LU/17/22/L

Second Floor Flat 36 South Terrace Littlehampton BN17 5NU

Listed building consent for the replace fire escape at rear of building

36 South Terrace – Proposed Fire Escape
North elevation

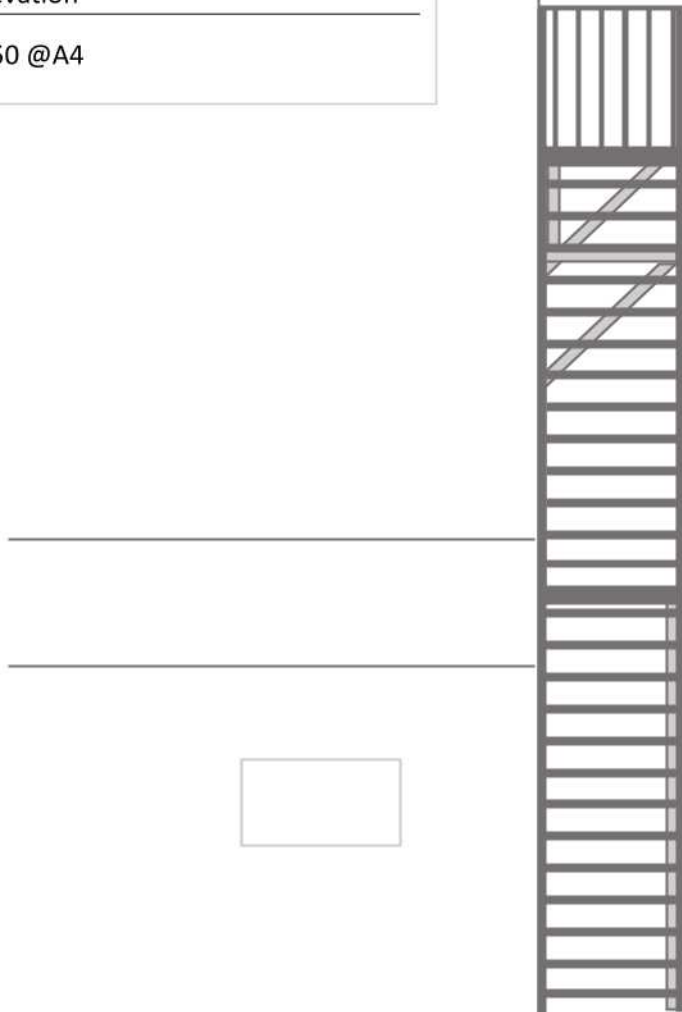
The proposal is to replace an existing fire escape at rear of building. The heritage statement helpfully identifies that the building was converted into the existing flat formation in about 1990, at which point the fire escape will have been added. It is noted from the plans that the intention is for the replacement staircase to closely resemble the existing one in terms of materials and appearance. This seems to be acceptable and will not cause harm to the listed building. Likewise, the location is such that the rear view of the listed building will be maintained.

Reference is made to the fact that brickwork repairs will be undertaken as part of the proposed works. I would suggest that any materials are appropriate for the listed building.
